APPLICATION NO. AW / 9 / 11

Single storey extension to existing office
Rose Green Junior School Raleigh Road Bognor Regis PO21 3NA

Single storey extension to existing office
Rose Green Junior School Raleigh Road Bognor Regis

EXISTING ELEVATIONS

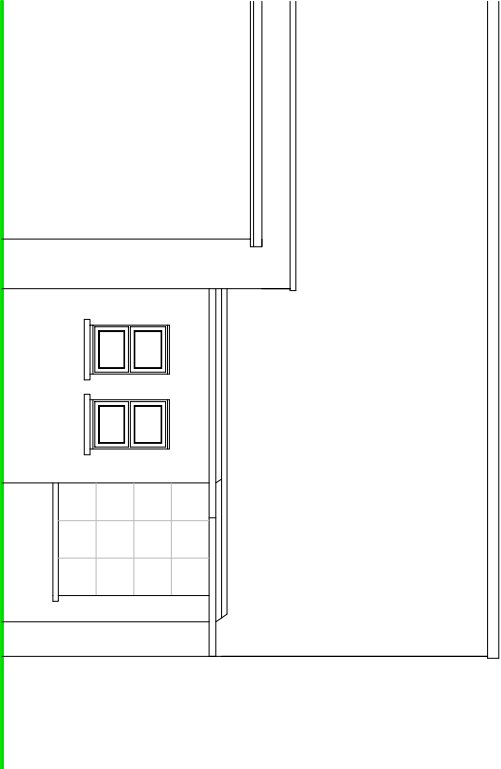
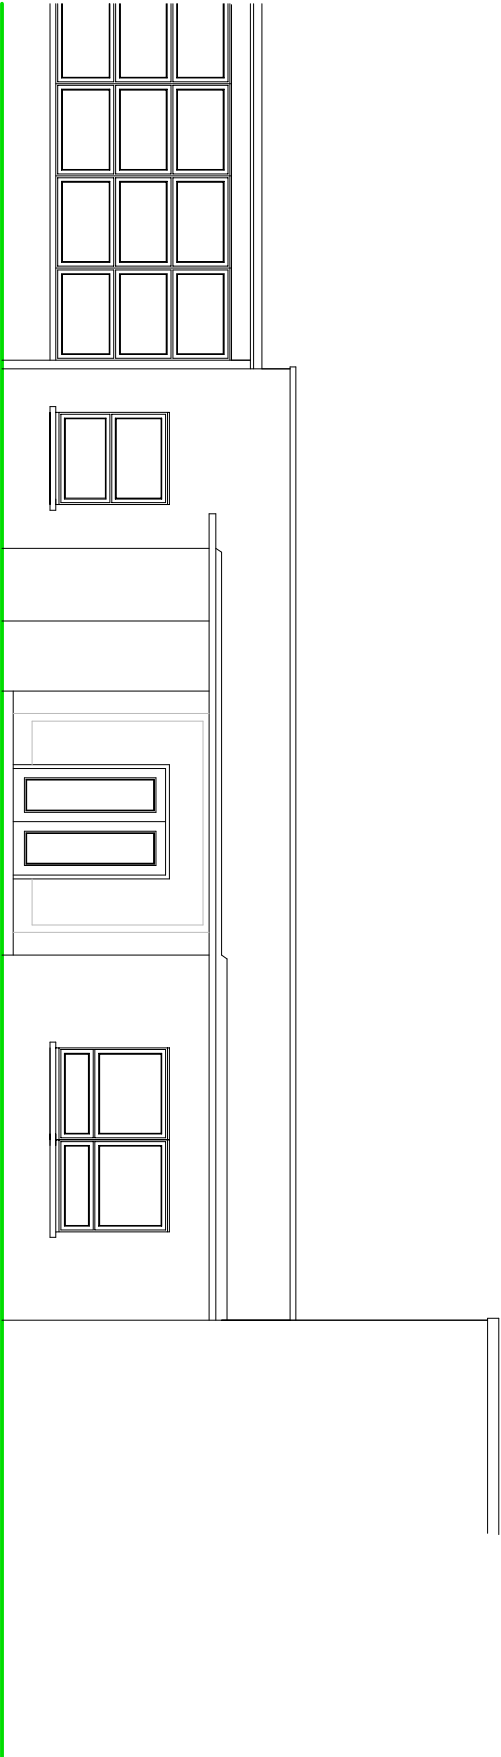
The windows on the existing and proposed front elevations do not accord with the existing and proposed floor plans. Please submit revised plans.

The existing and proposed side elevations show a window which is not shown on the existing and proposed floor plans. Please amend.

PROPOSED GROUND FLOOR PLAN

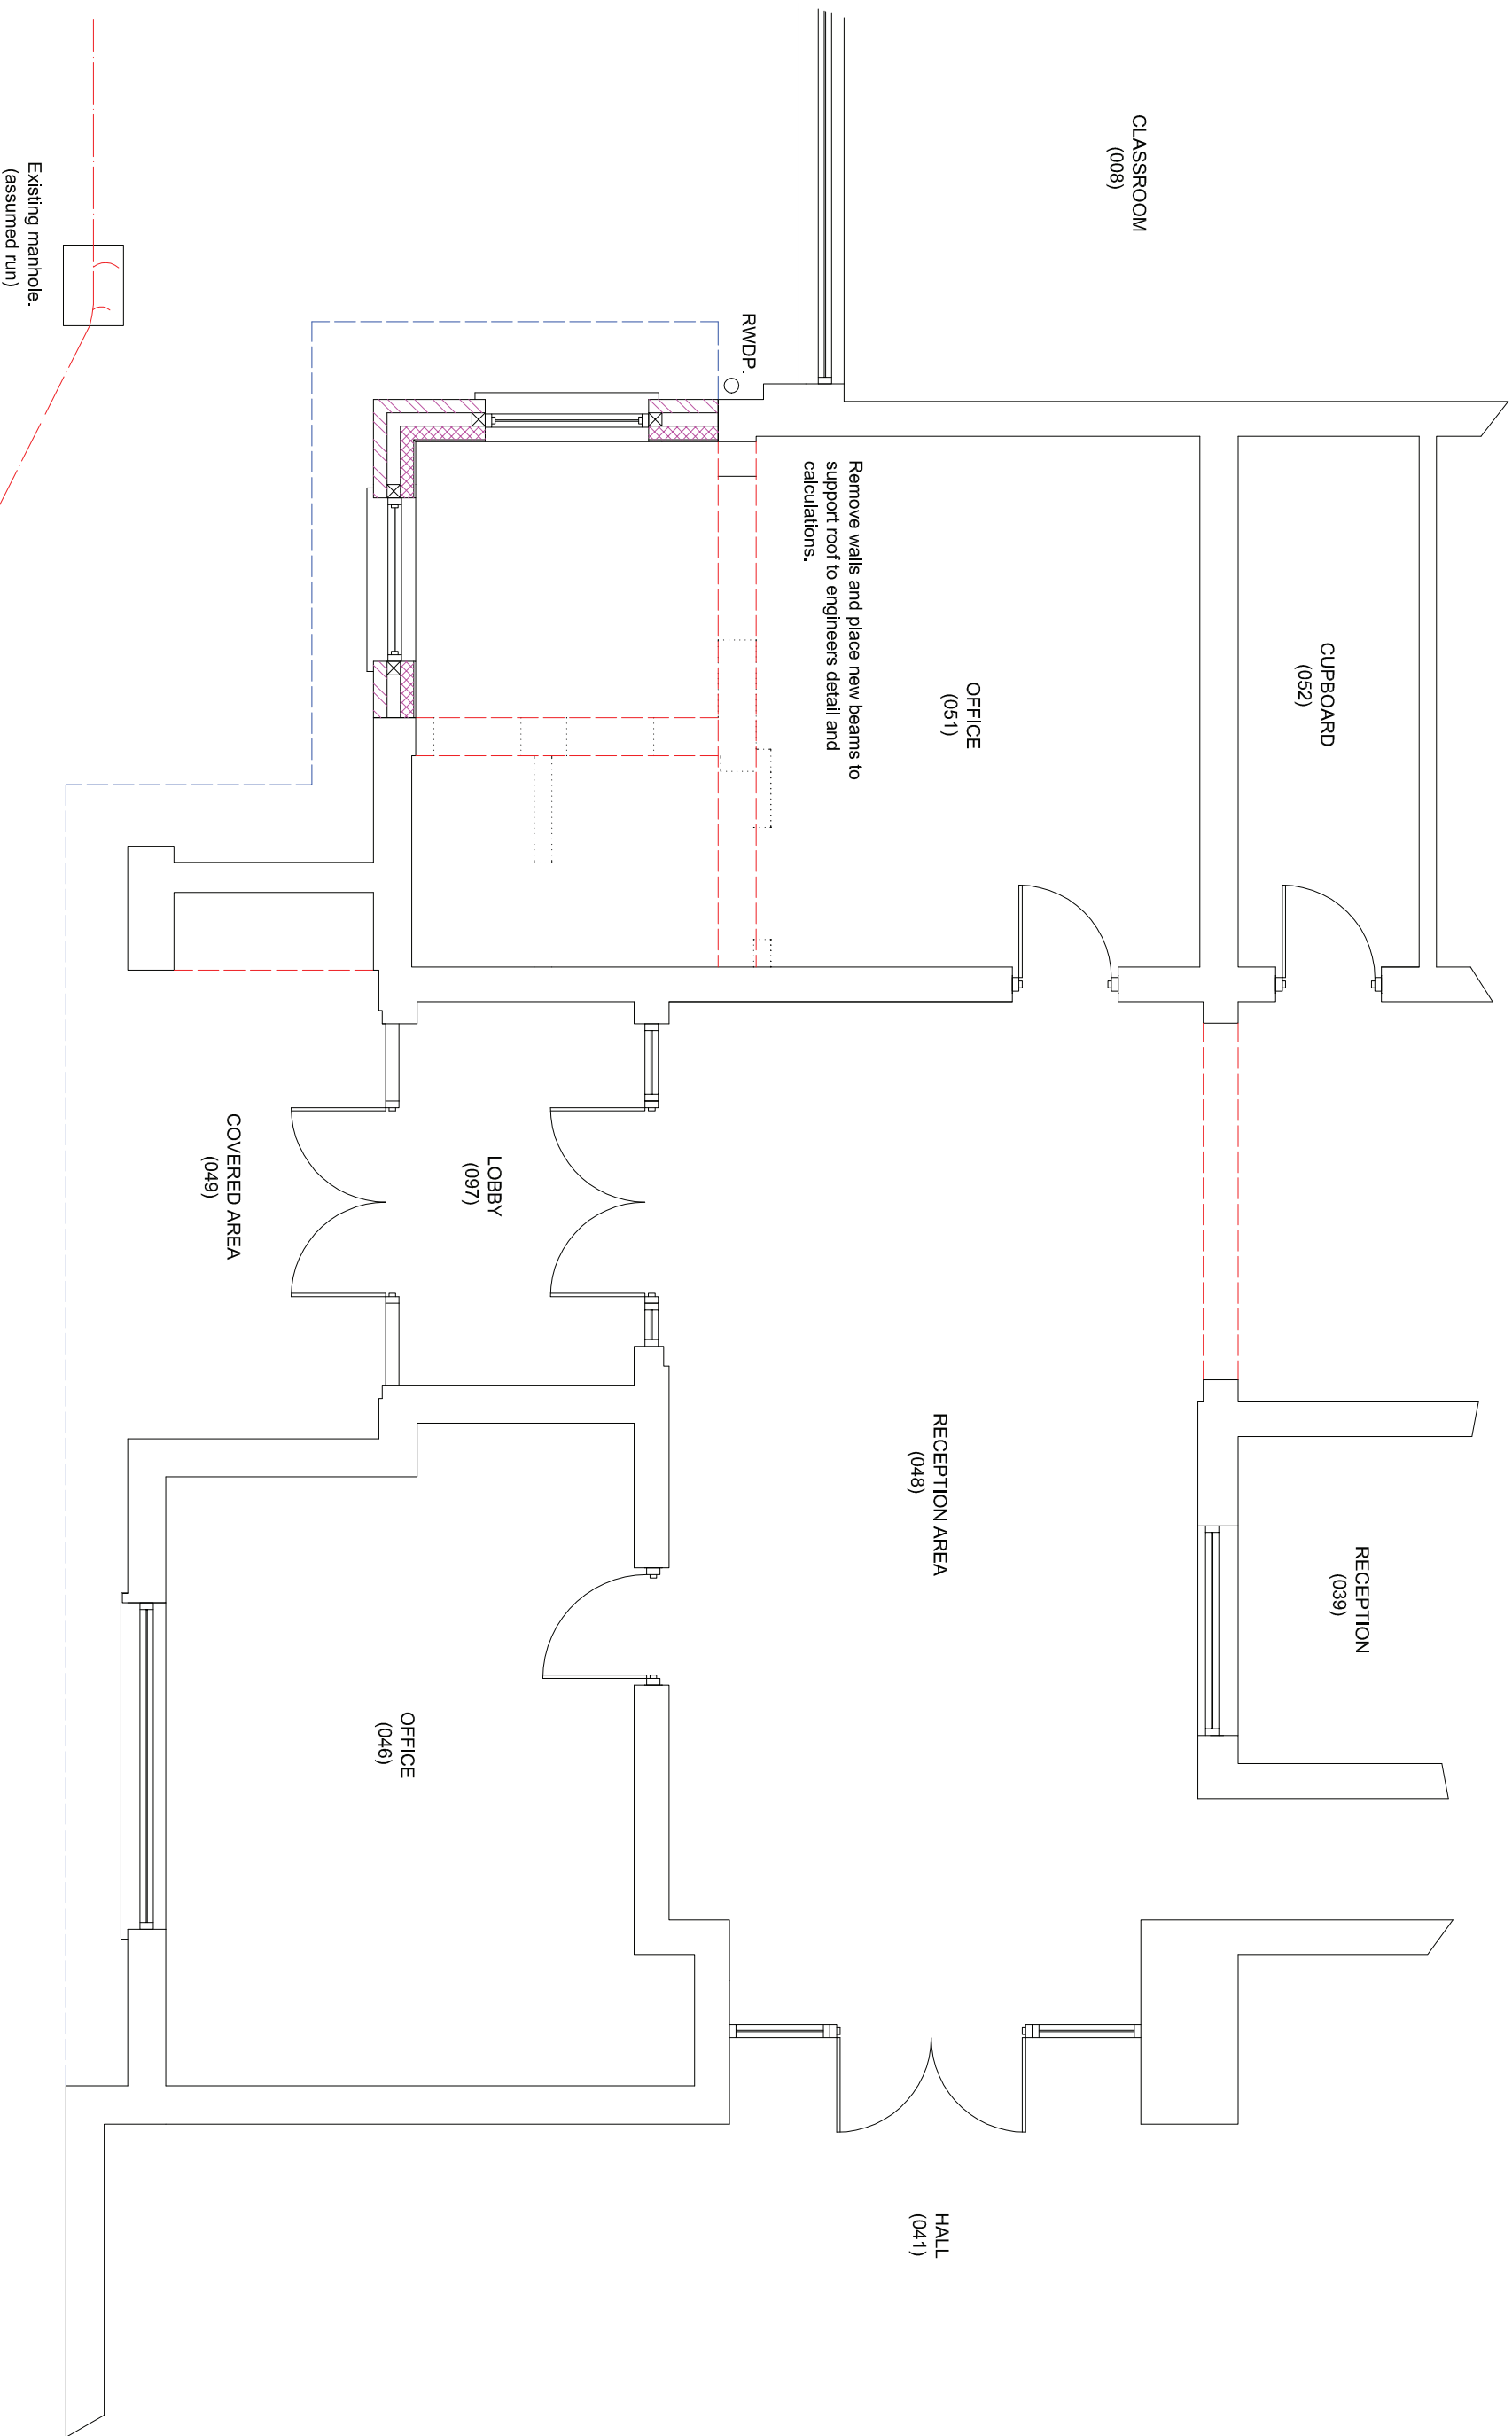
There is a plan labelled 'proposed floor plan' which shows an elevation/section of the building. Please provide a revised plan re-labelled.

I attach revised floor plans and cross section as requested – I hope I have covered the queries raised, however, if there is anything else – please let me know.
